Re: Comments in Reply to DECC Assessment – Waterbrook Nield Avenue, Greenwich

The following comments are made in response to the statements made by Debora Stevenson, Senior Regional Operations Officer, NSW Dept. of Environment & Climate Change (DECC) dated 18/12/08.

Landscape Plan extract showing the proposed development footprint

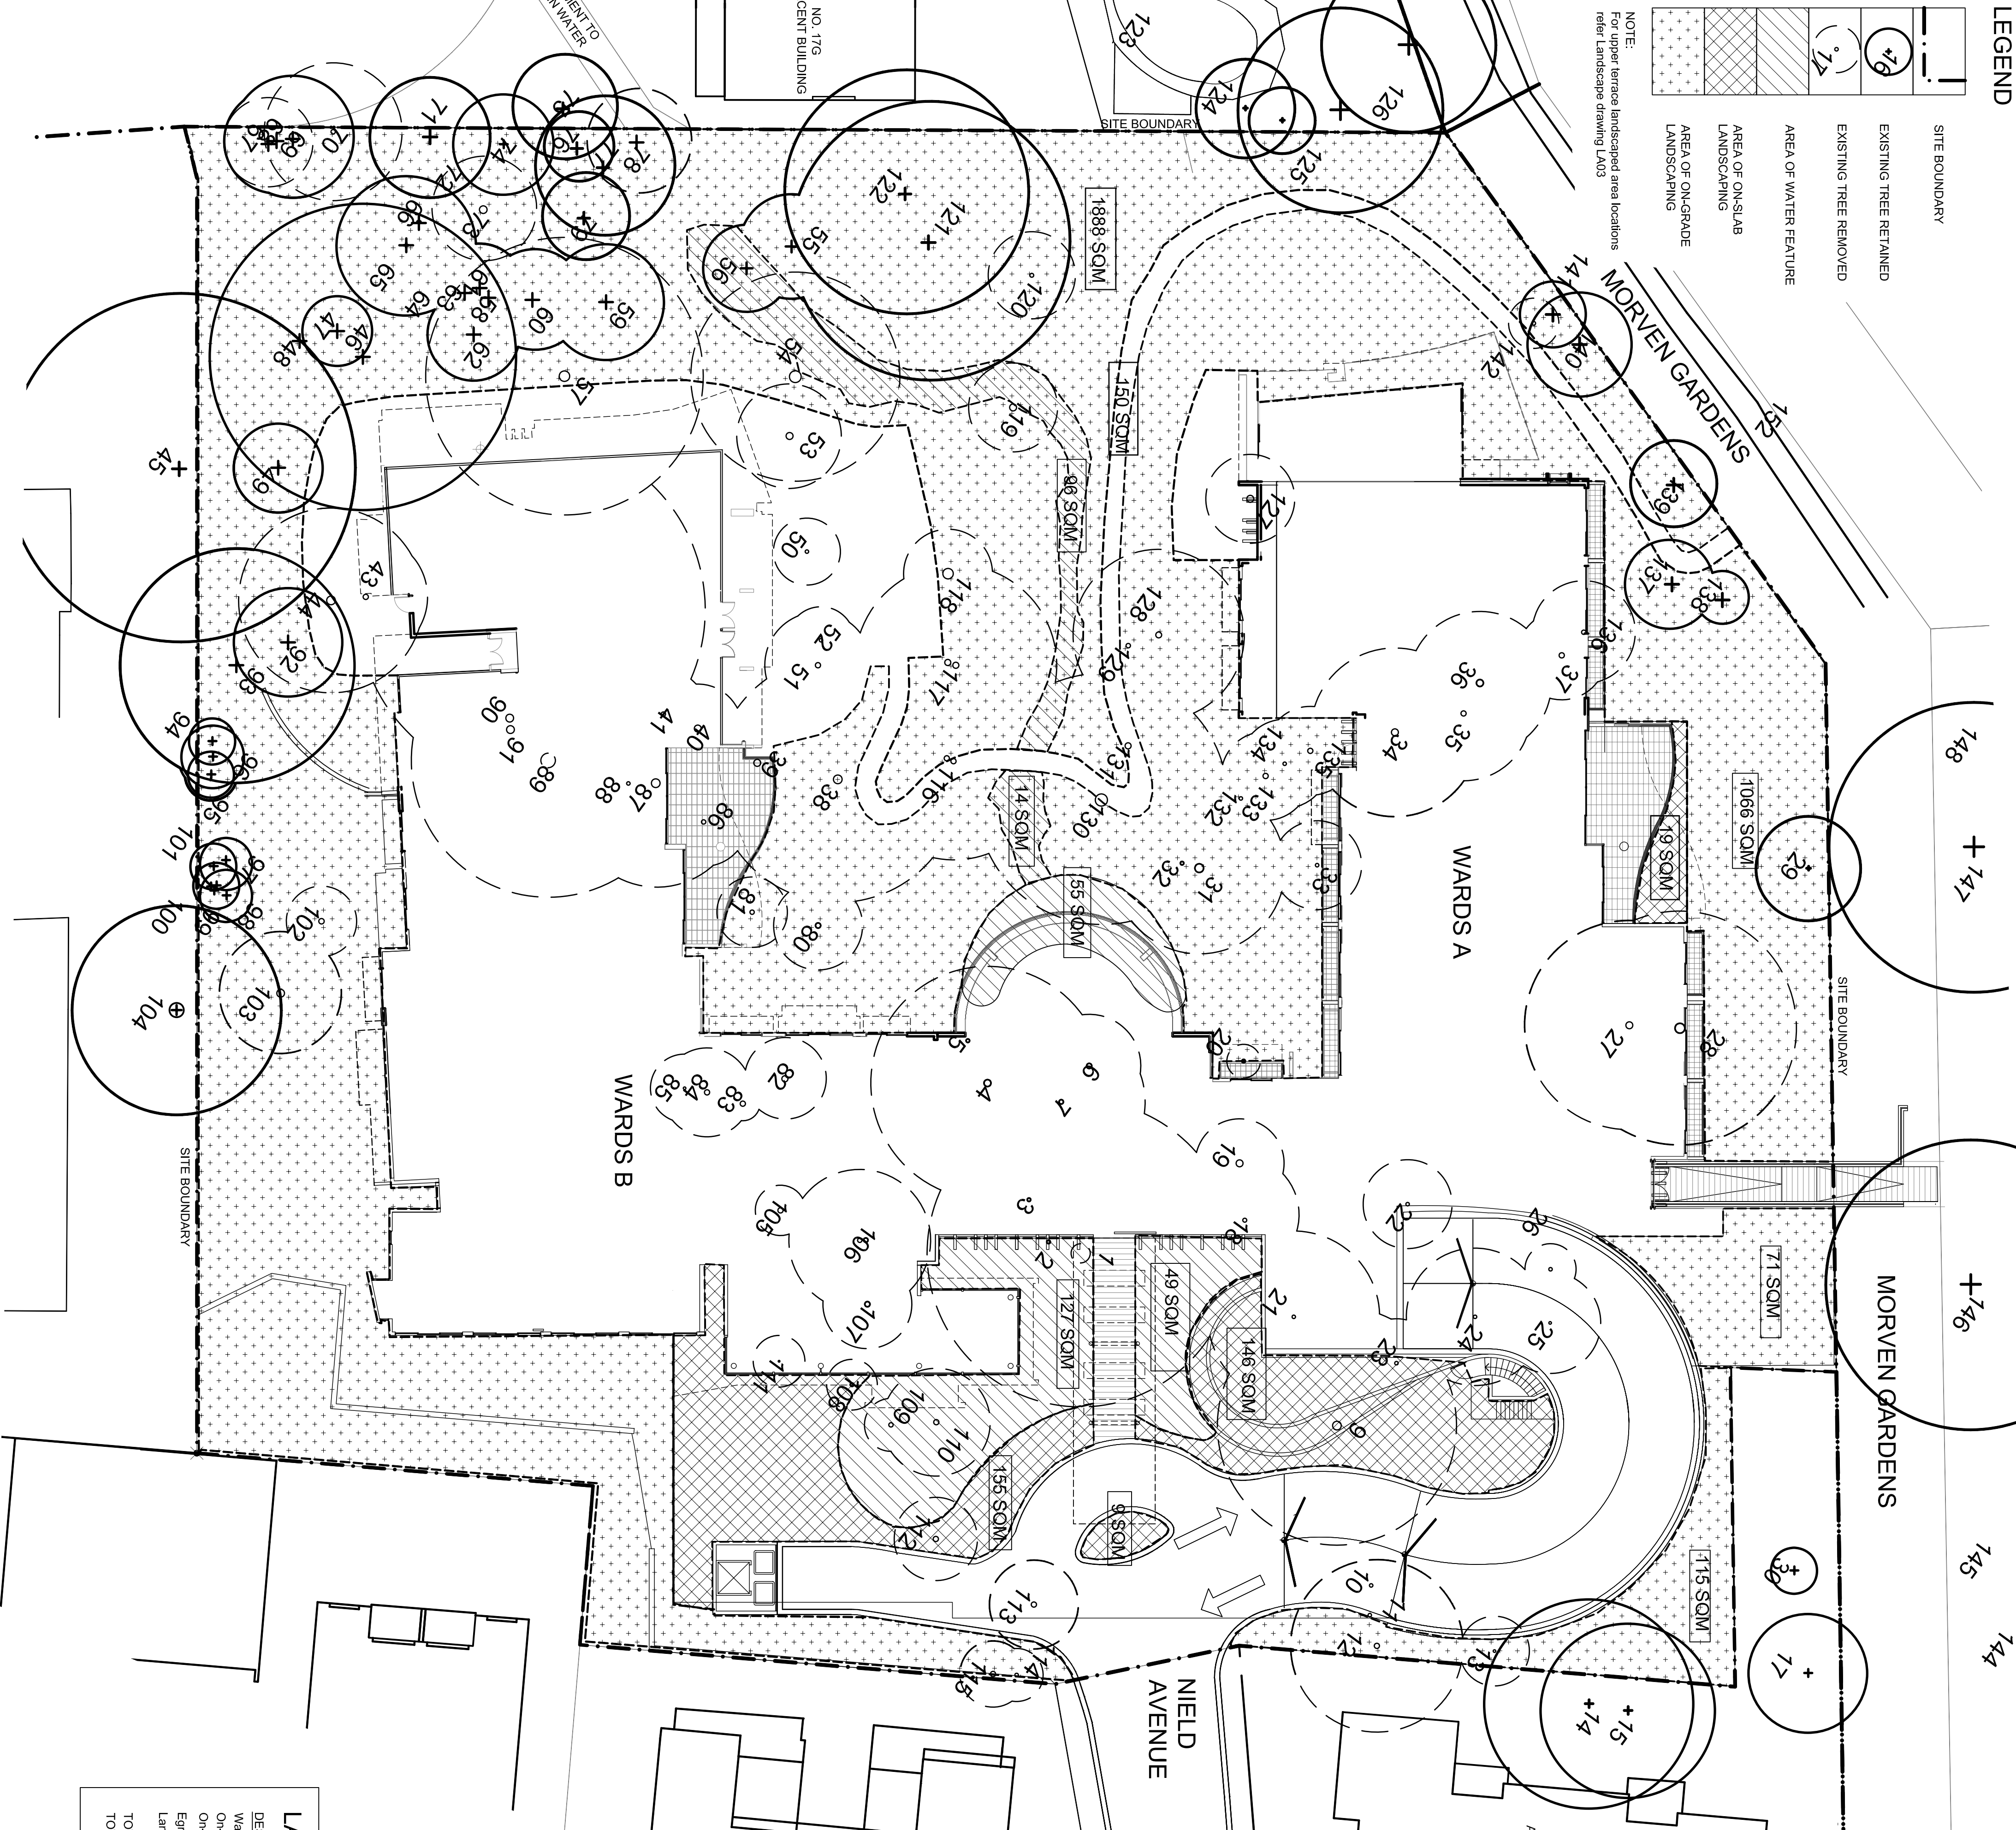
I agree with the DECC officer's comments in that retention and rehabilitation of the site will require active management; however, from an ecological perspective it is considered that rehabilitation works, of any size or configuration within the site boundaries, will not result in a viable remnant pocket of native vegetation and active management will be required. This is evident by the current condition of the site's where it has generally received little positive maintenance and is currently in a state of biodiversity decline.

I agree with the DECC officer's comments in that the Urban Gully (Area C) has the most potential for rehabilitation works having semi natural topography. Based upon the Flora & Fauna Assessment 10/10/08 and the proposed development plans this Area C is, albeit, outside the building footprint of Wards B within the landscaped areas. In addition to this removal of the existing swimming pool and surrounding deck in the south eastern corner of the site will increase the area to be rehabilitated along with other areas along the south western boundary.

Given the small size of the Urban Gully (Area C), the existing limited biodiversity values, the indirect surrounding landuse impacts, retention of the Urban Gully (Area C), configuration of the areas for rehabilitation / landscape works and the need for active management, it is considered that modification of the Ward B building footprint will not influence the long term viability of the rehabilitation / landscape works.
